## Application for Removal or Variation of a Condition following Grant of Planning Permission or Listed Building Consent

Erection of two dwellinghouses.

DC/078031

Condition 1 (Approved Plans).

SCALE 1:100 @ A3 DWG: 014.

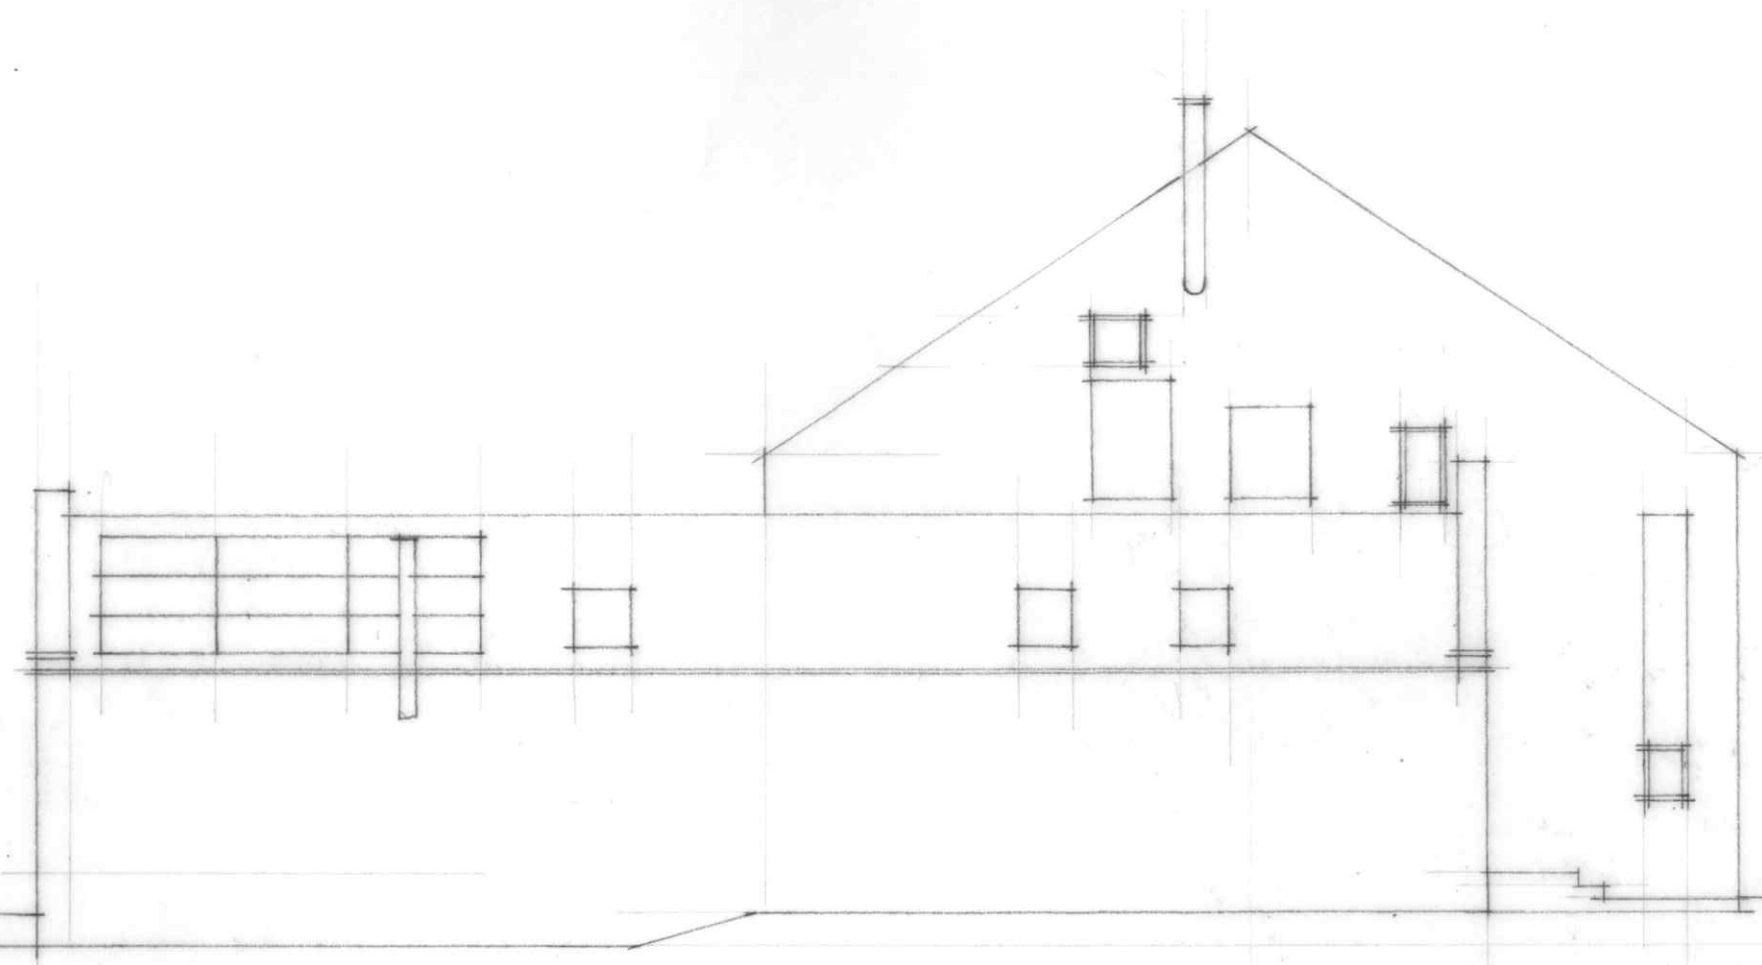
Elevations amended to show adjacent dwellings more accurately.

- Add South and North Elevations ref. 012 (replacing side elevations 007 Rev C)
- Add East and West Elevations ref. 013 (replacing rear elevation 006 Rev C and front elevation 008 Rev B)
- Add Rear Elevation to 271 + 273 Bramhall Lane South ref. 014
